# **APPLEGREEN PLC**

**DEADLINE 5 SUBMISSION**

**M42 Junction 6  
Development Consent Order Application**

**COMMENTS ON RESPONSES RECEIVED AT DEADLINE 4 (RELATING TO THE  
EXAMINING AUTHORITY'S SECOND WRITTEN QUESTIONS)**

Figure 1: Junction 5a Free Flow Alternative Layout

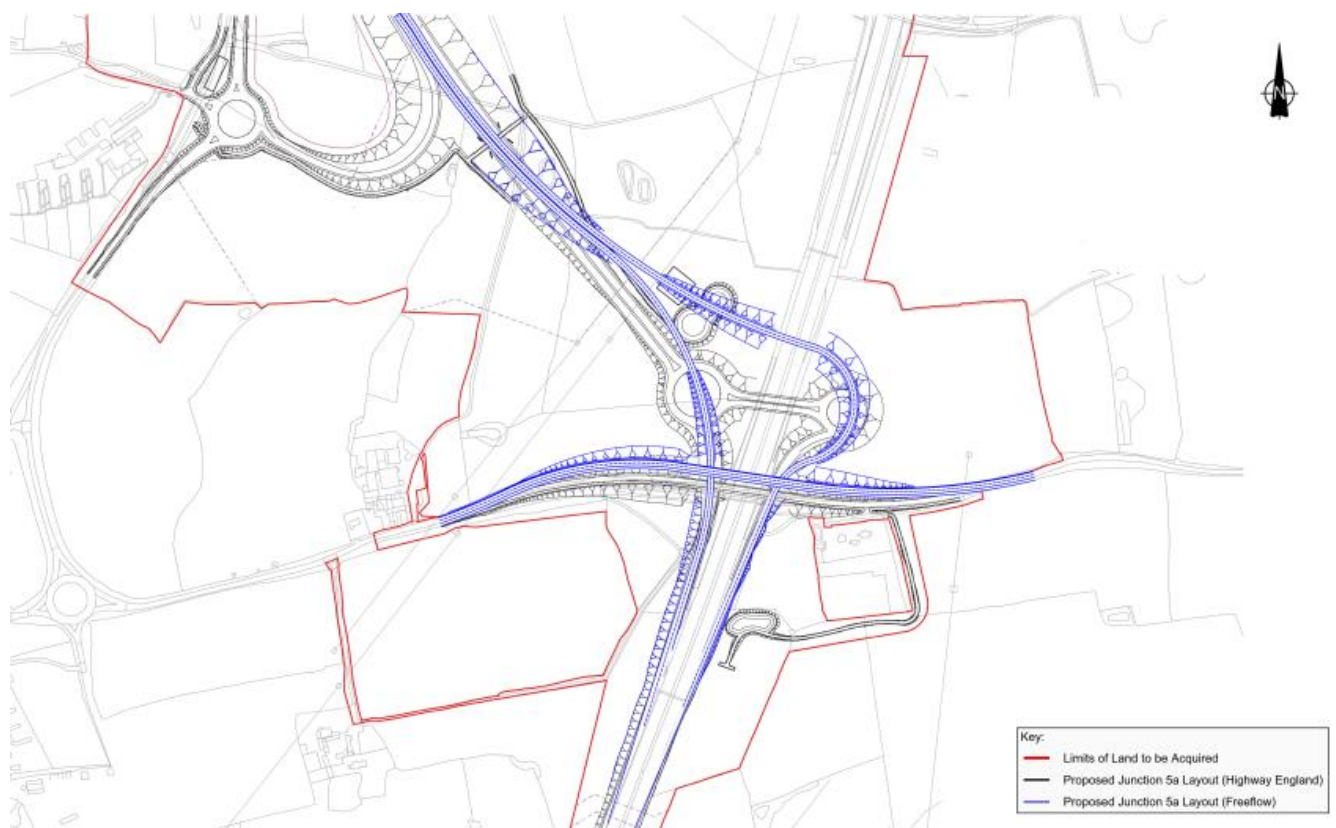
2.1.5.	The Applicant, SMBC, WCC, Extra MSA Solihull Ltd and Applegreen plc	<p><b>MSA and junction 5a</b>            Please revisit and reassess the advantages claimed for the proposed dumb-bell design for junction 5a in the answer to ExQ1.0.10 in relation to the free-flow design suggested by Applegreen in their Technical Note appended to REP3-024. Since a consequence of the proposed design necessitates the widening of the western roundabout and a section of the link road in order to accommodate MSA traffic, please include all those alterations in the reassessment (particularly, the additional lanes and the additional span of Solihull Road Bridge</p>	<p>In response to this question, the Applicant states that they have prepared a free-flow layout that complies with DMRB which they have used to compare a free-flow layout with a dumb-bell. As the Applicant has not provided a drawing of their free-flow layout, the Applegreen comments that follow have not benefitted from reviewing it.</p> <p>The Applicant states that their free-flow layout would require 12% more land than the dumb-bell scheme. They note that the increase does not include the additional land that would be required to install attenuation features north-west of the junction. It is not clear if the Applicant has considered whether the attenuation features could be accommodate on land within the land take of the free-flow junction. It would be expected that the size of these attenuation features would be smaller with a free-flow layout than a dumb-bell as the total carriageway area would be smaller.</p>

Figure 4: Relative Impact on Ancient Woodland

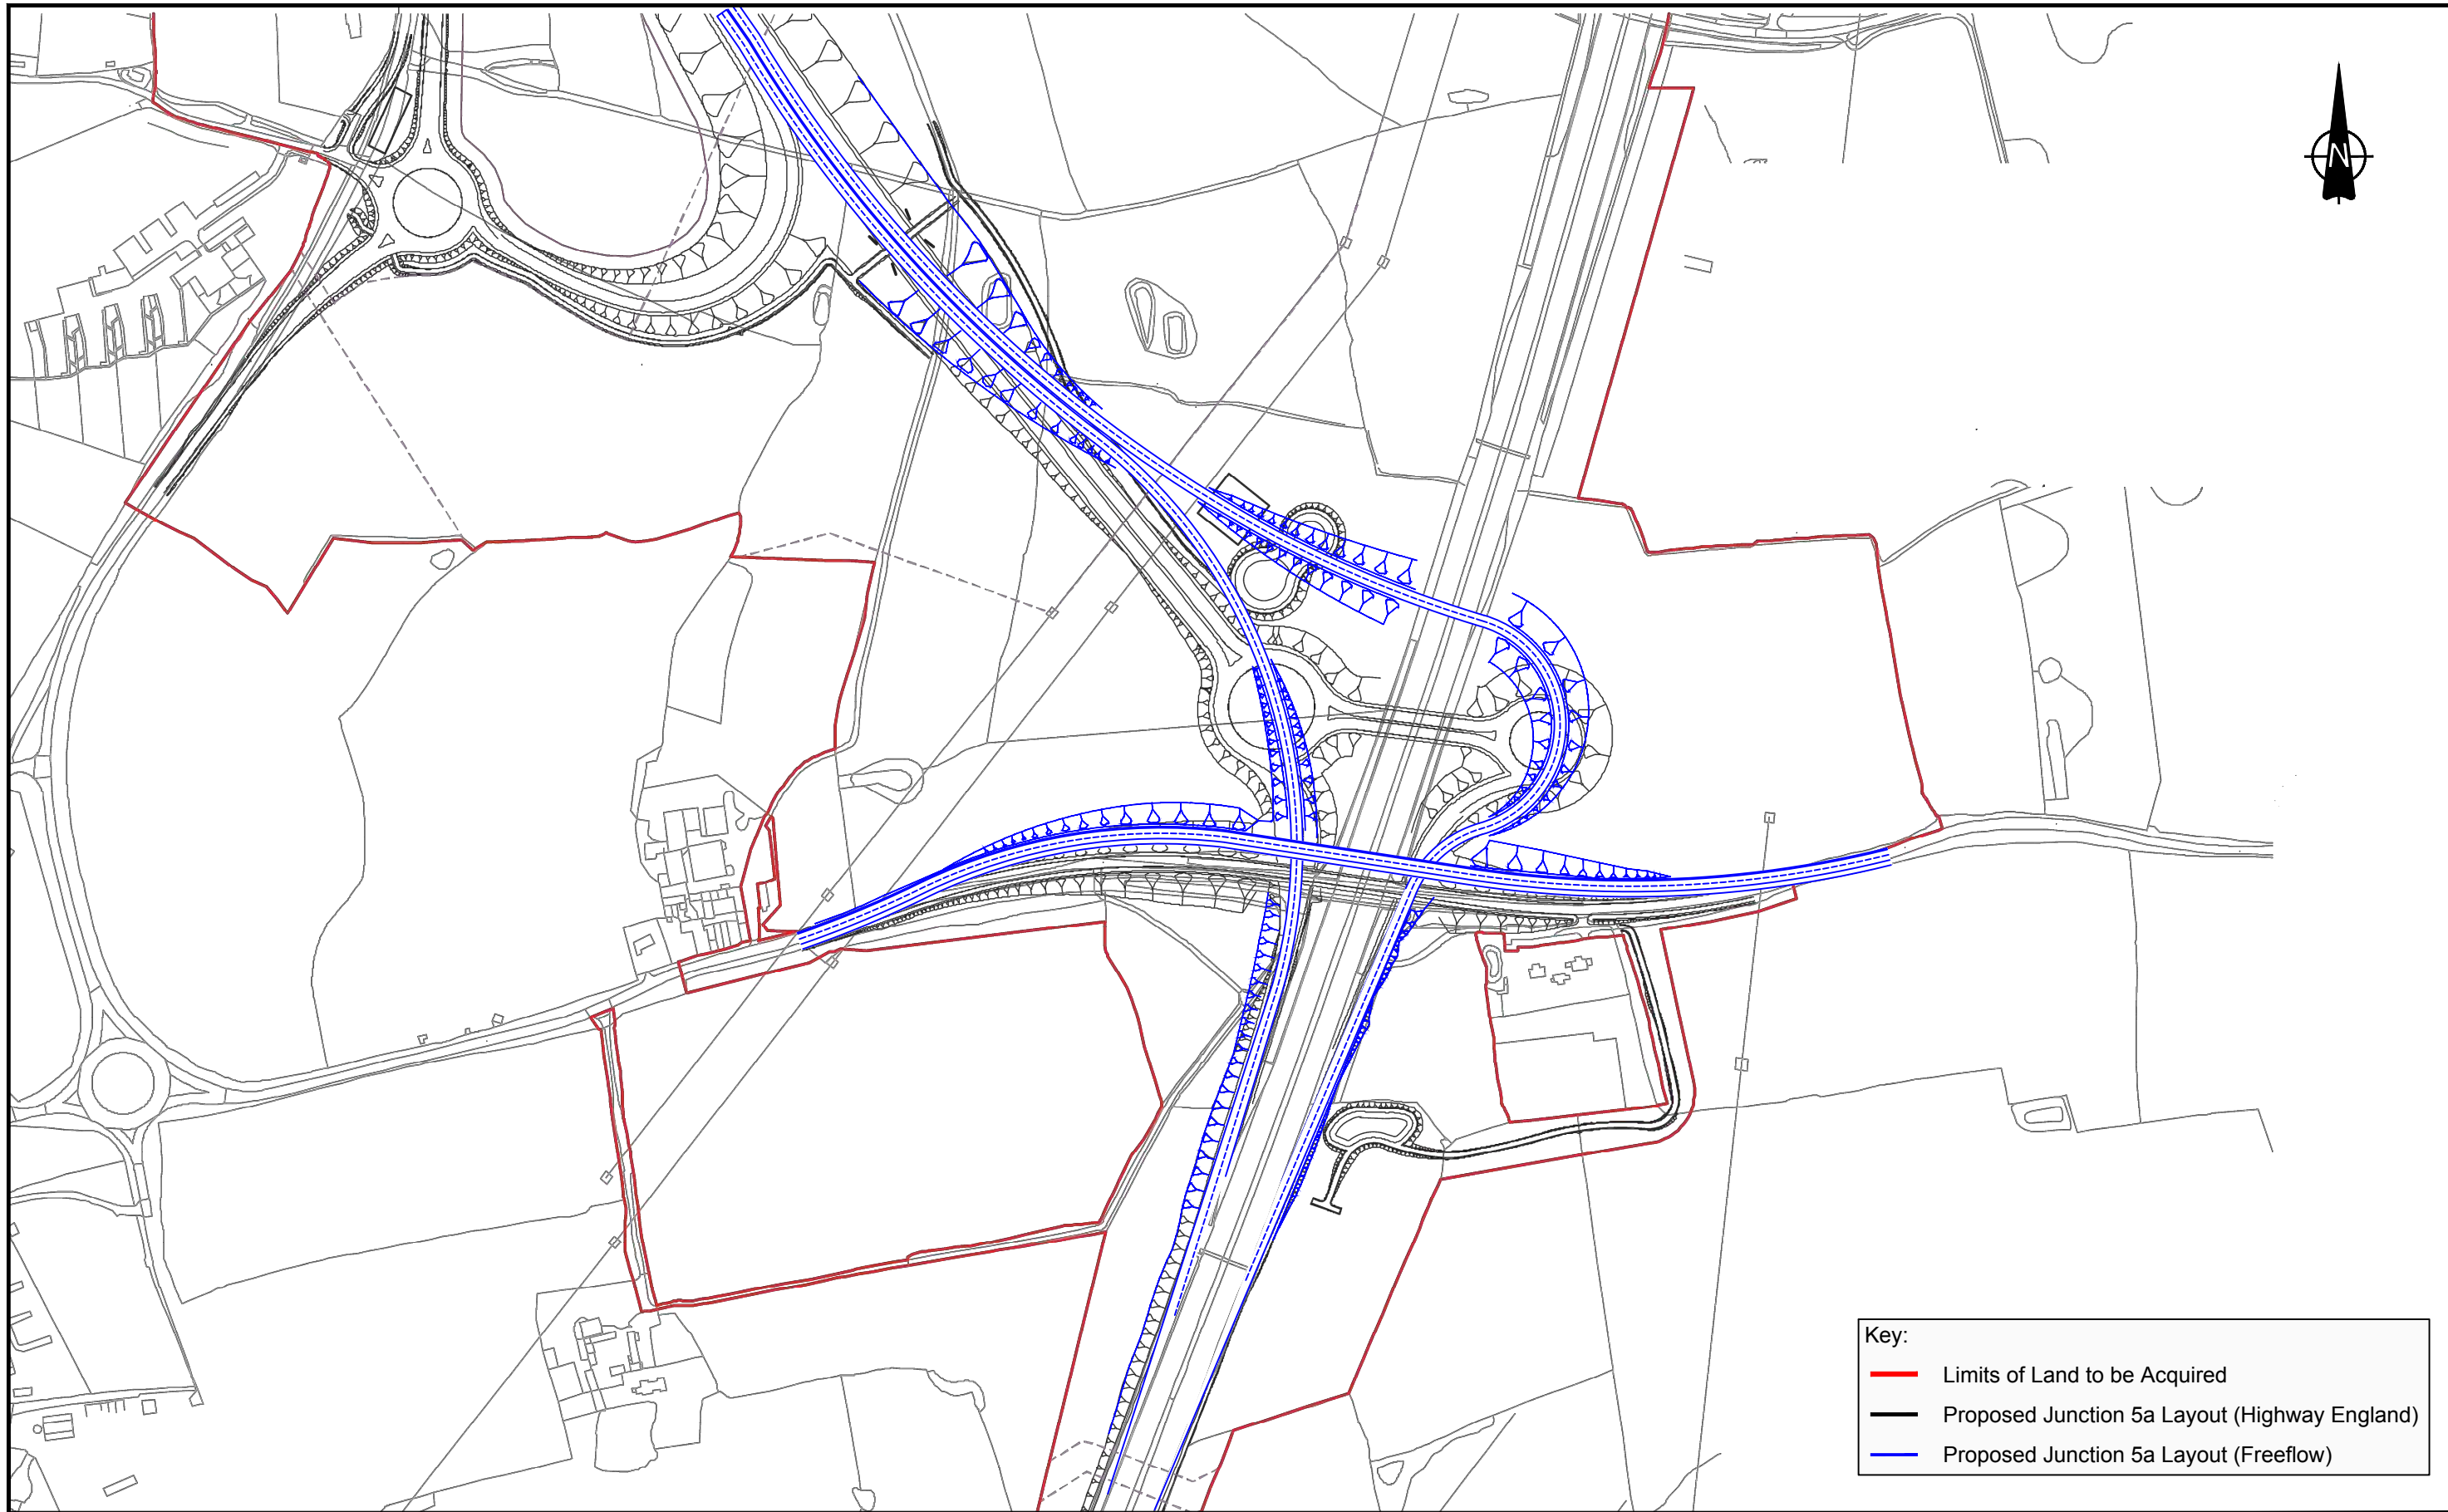
<p>required). In the light of that reassessment, does the published layout in the dDCO provide the optimum junction arrangement and meet the scheme objectives as defined in the Planning Statement?</p>	<p>It is interesting to note that the Applicant accepts that the impact on the ancient woodland would be less with the free-flow proposal. The Applicant has identified the reduction as 800 sqm when compared to the dDCO scheme. Without a layout plan it is not possible to see if their assessment of the free-flow scheme has allowed for the potential revision to the horizontal and vertical alignment of Solihull road that would further reduce the impact on the ancient woodland.</p> <p>The Applicant suggests that the free-flow scheme would have a greater adverse impact on operational safety due to higher traffic speeds. This comment appears to ignore the safety benefit of the removal of the speed changes, braking and vehicular conflicts associated with the dumb-bell layout.</p> <p>The Applicant states that a free-flow layout precludes any opportunities to connect additional road infrastructure with Junction 5A in the future. Applegreen assume that this means that it does not provide for an MSA or a connection to the local road network east of the M42. Neither of these considerations are identified as scheme objectives.</p>
